RESPONSE TO SUBMISSIONS REPORT

SSD 34919690 – MOD 2
39-43 HASSALL ST PARRAMATTA

APRIL 2025

Drawing No./ **DA06.14**

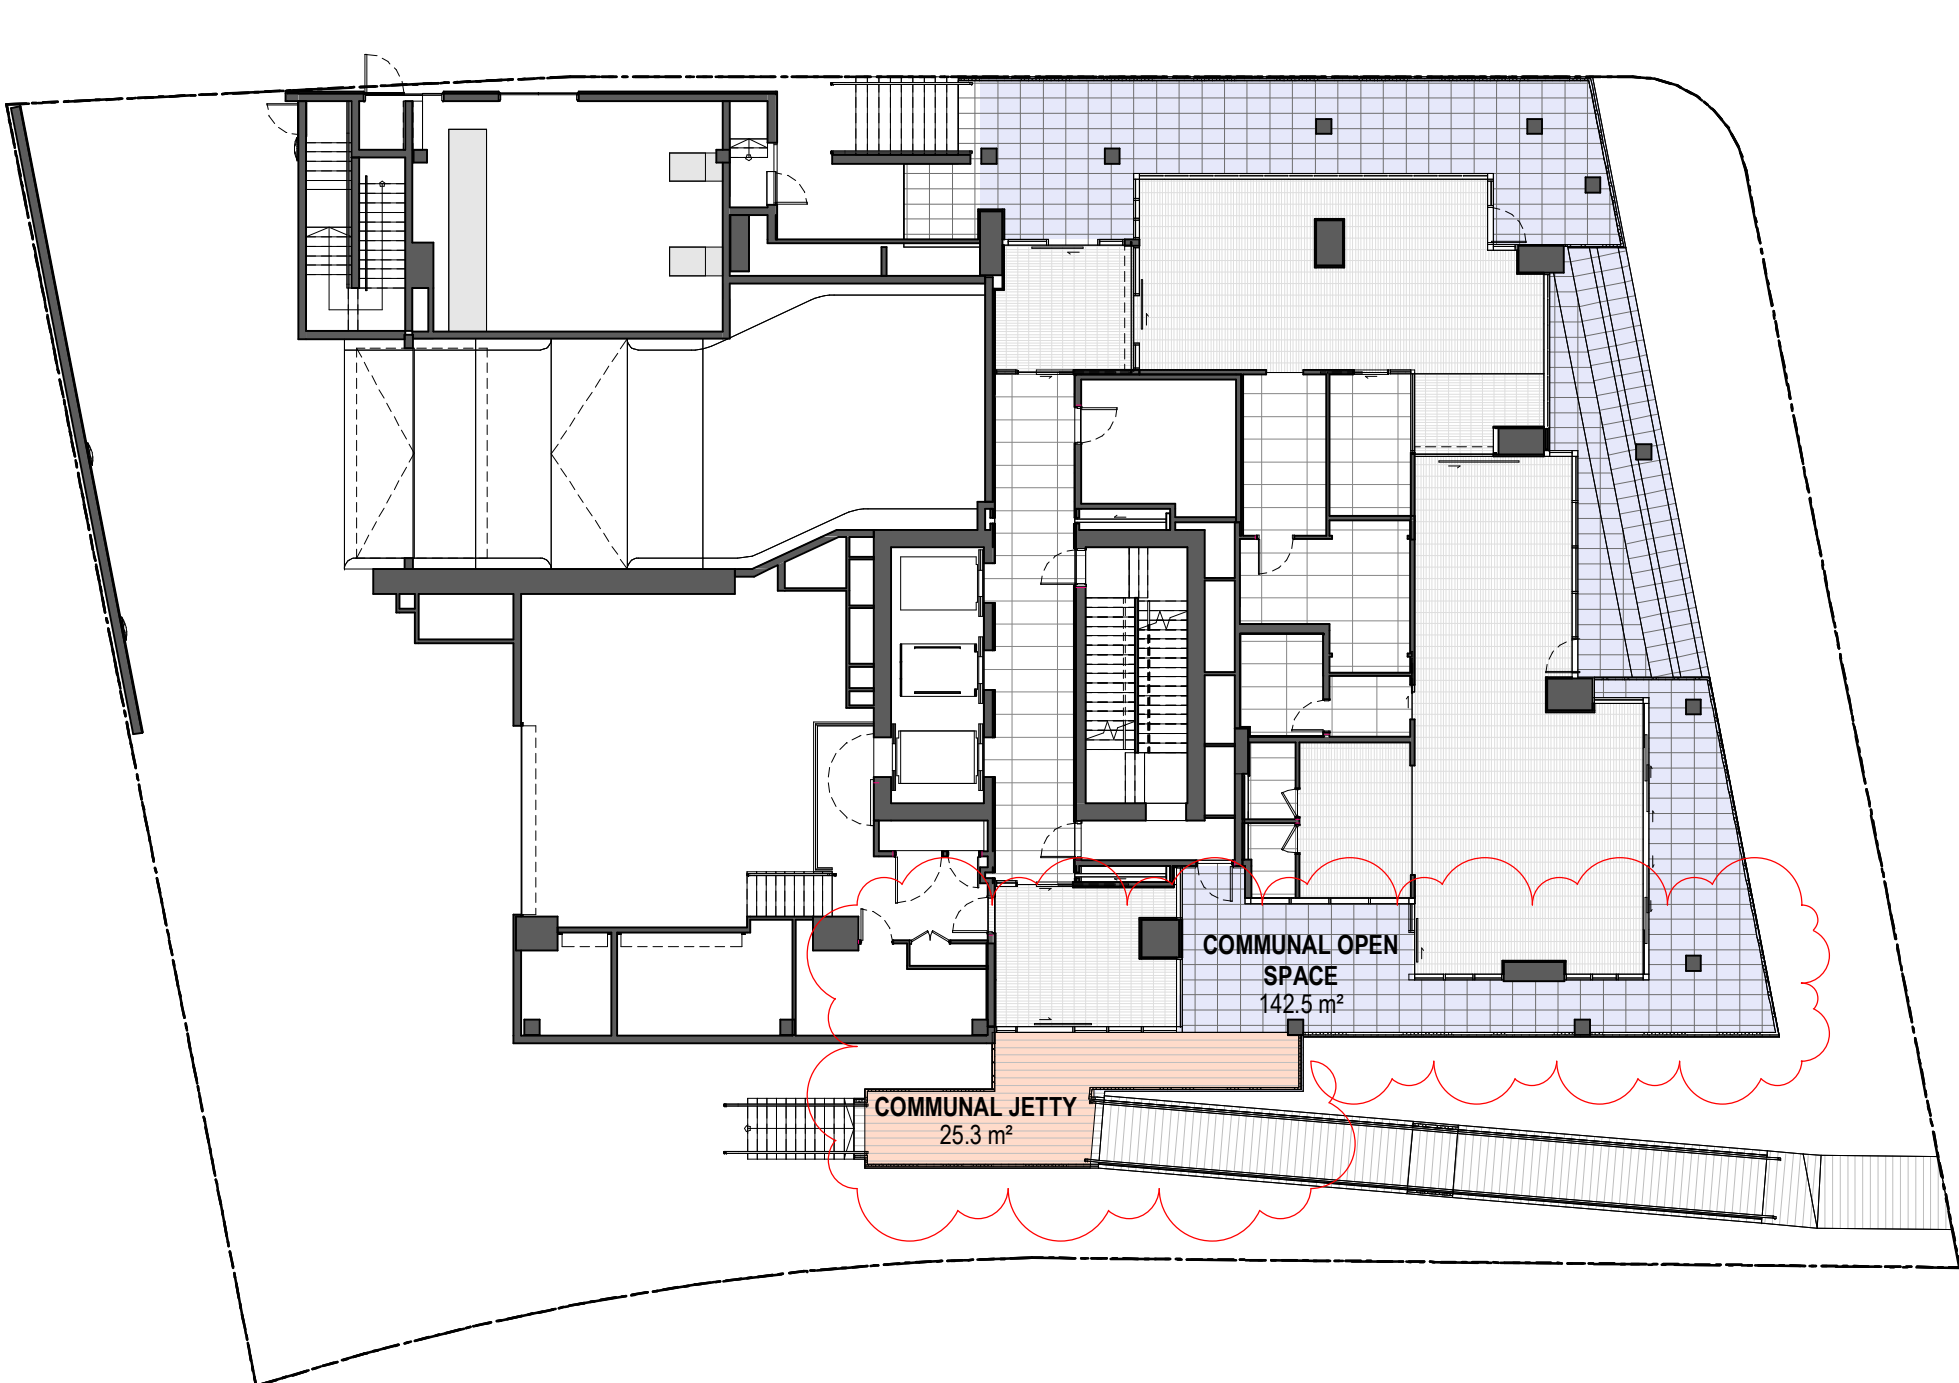
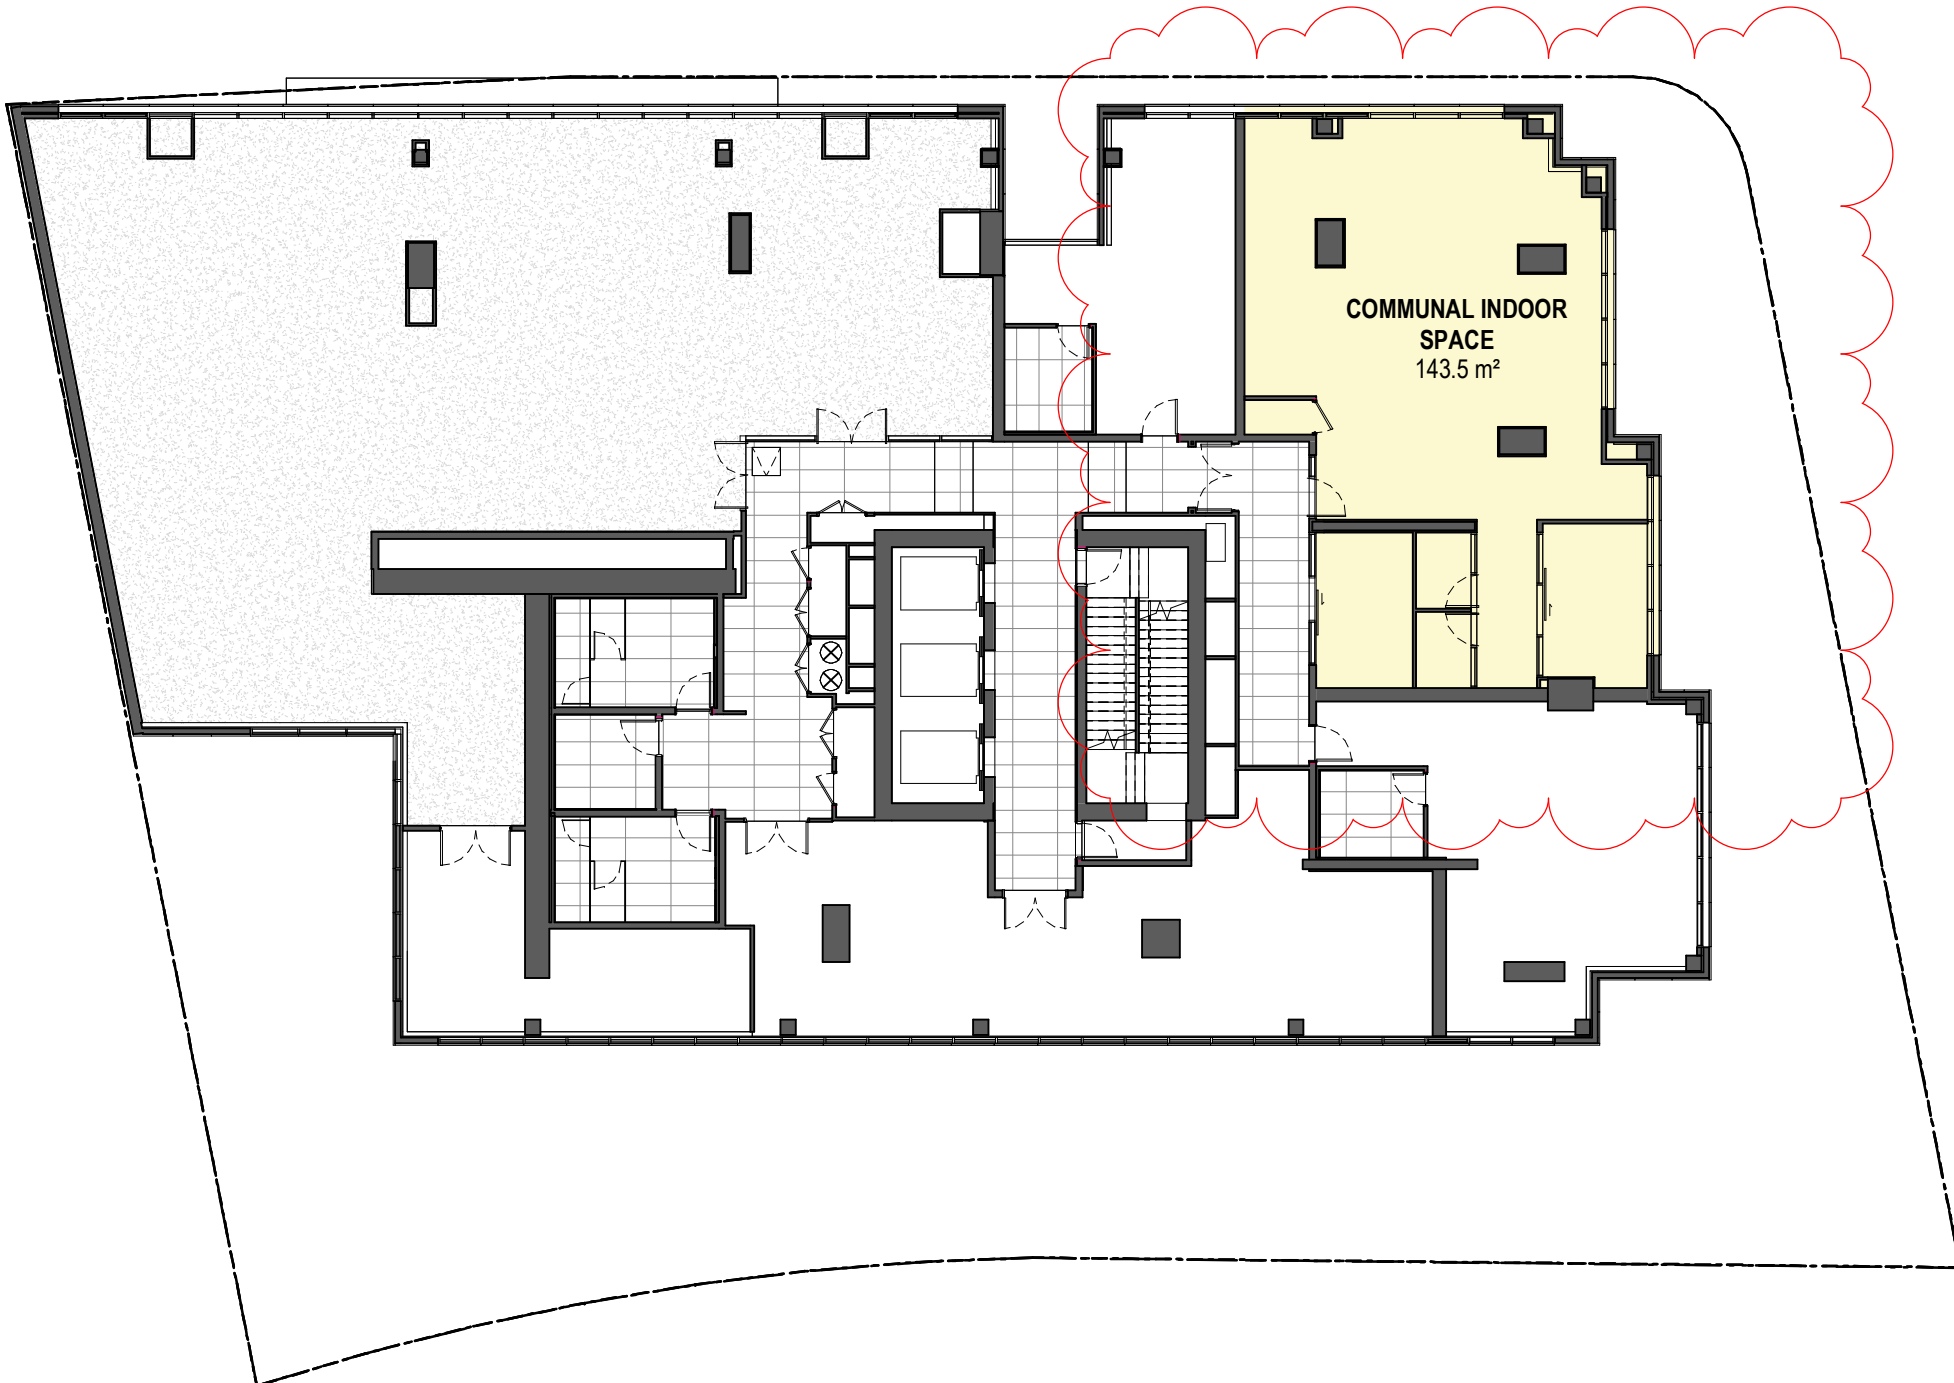
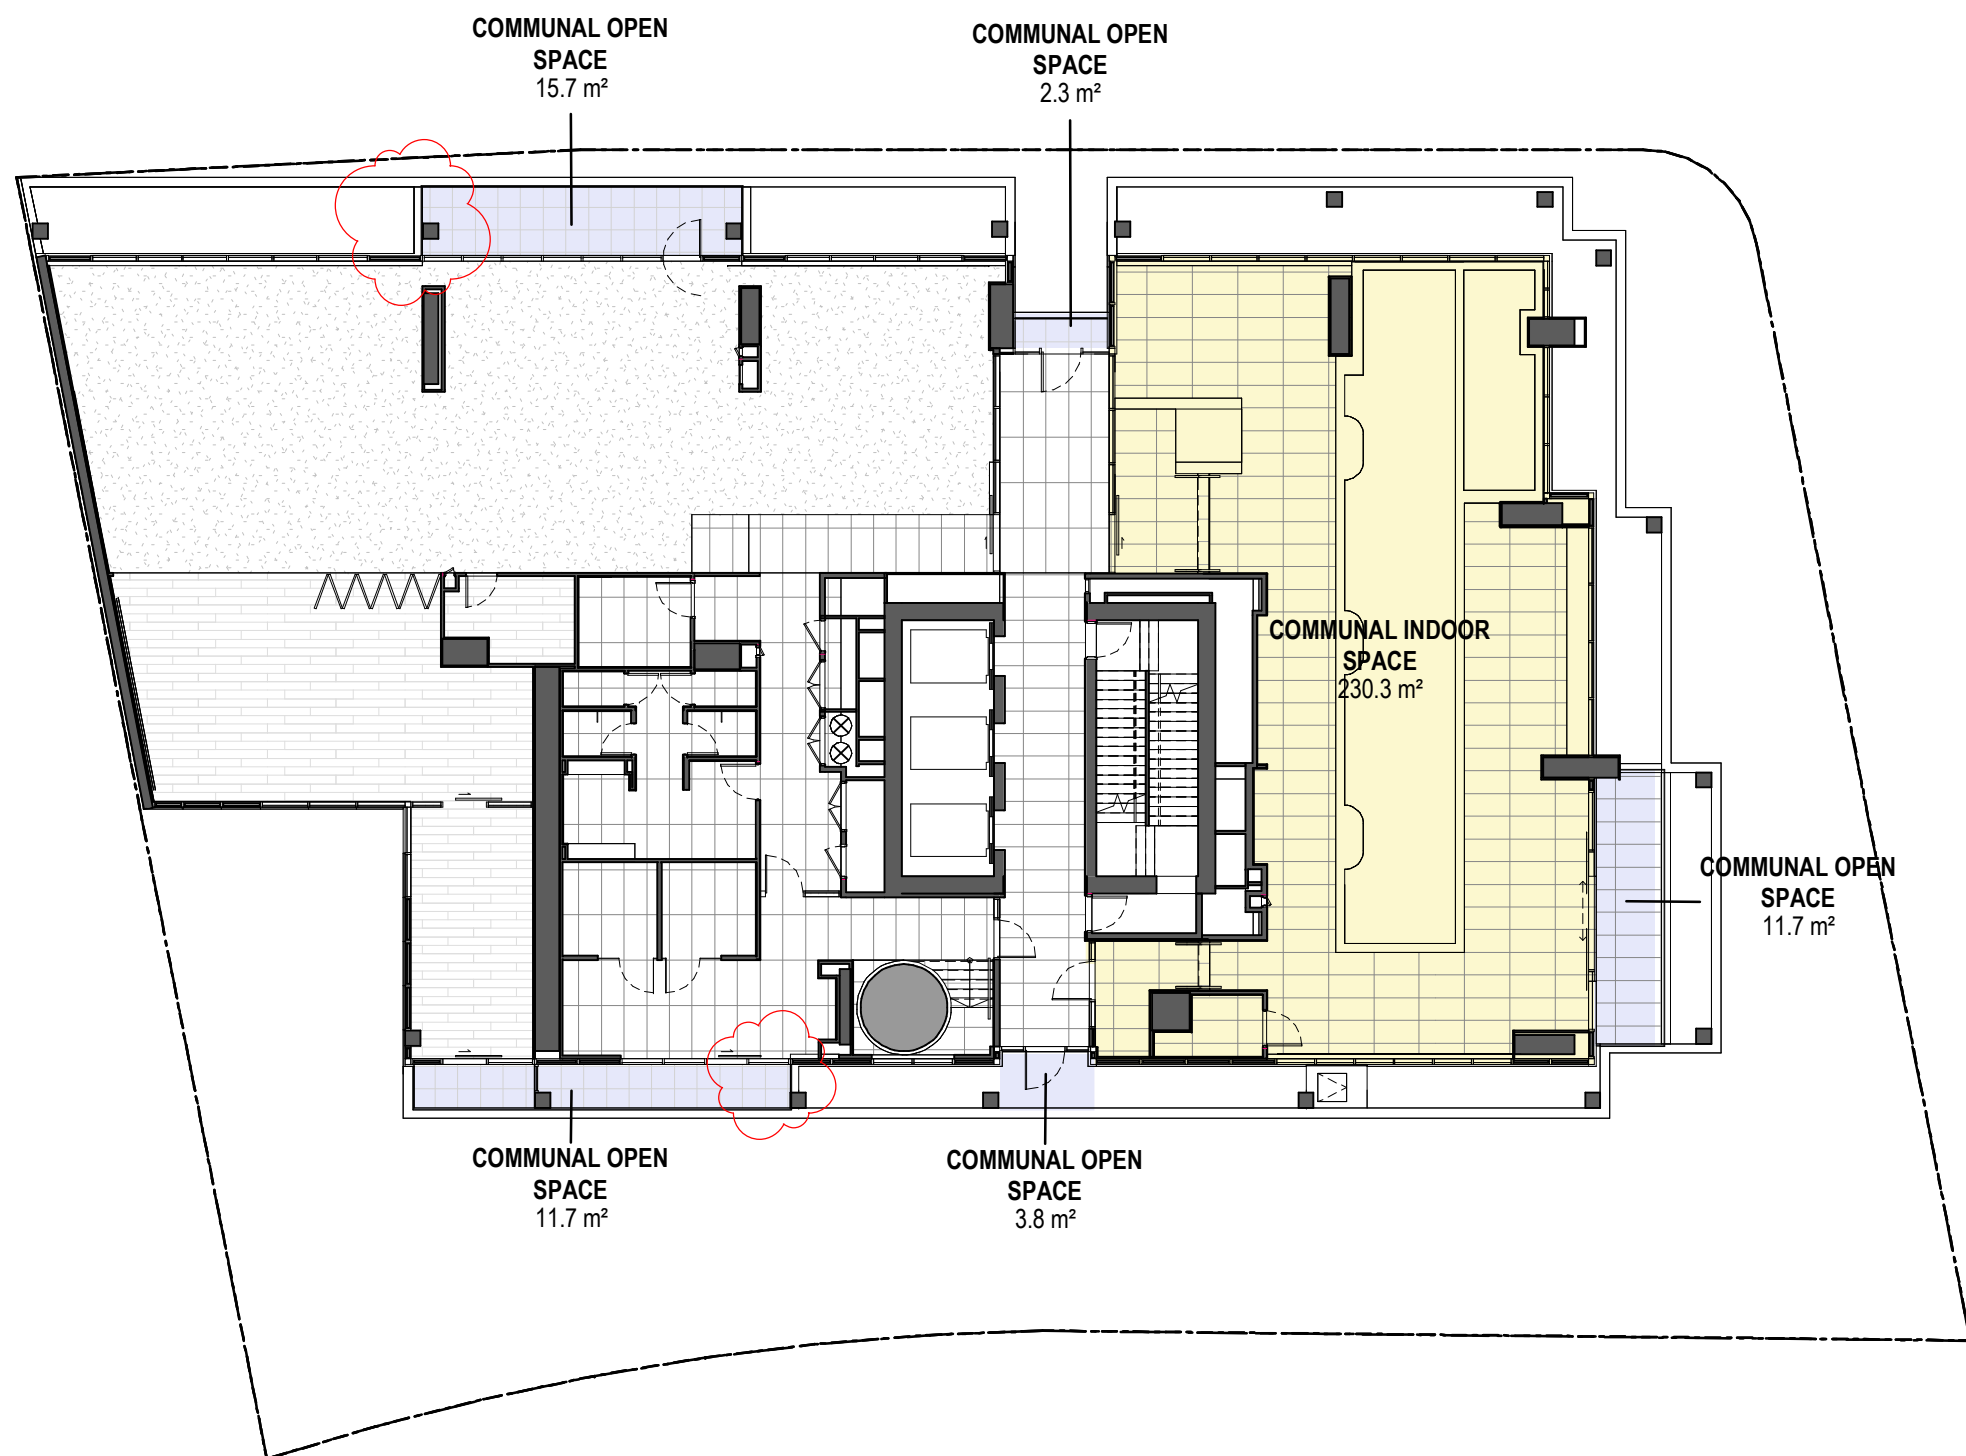
COP 2	• Council has reviewed the revised landscape report for the modification application and raised concern over the location of 4 x Tristaniopsis laurina (Watergum) trees, at ground level, that are shown to only be planted between 0.45-0.5m away from the approved building. This is not considered to be ideal. The proximity to the building means the trees will clash with the building façade, causing on-going building maintenance issues. Constant pruning will be required, resulting in the poor form, structure and overall decline of the proposed trees. The likely outcome of this will be the eventual removal of the trees from the site.	The Tristaniopsis laurina (Watergum) trees have been relocated 3m away from the building line as part of this amended proposal. Trees were conflicting with surface stormwater pipes have been removed.
COP 3	• Section B of the application's accompanying landscape report incorrectly illustrates the location of Tristaniopsis laurina and shows the tree as clashing with the building façade	The landscape plan has been amended to have to be consistent with the architectural plans with no clashing of the building façade.
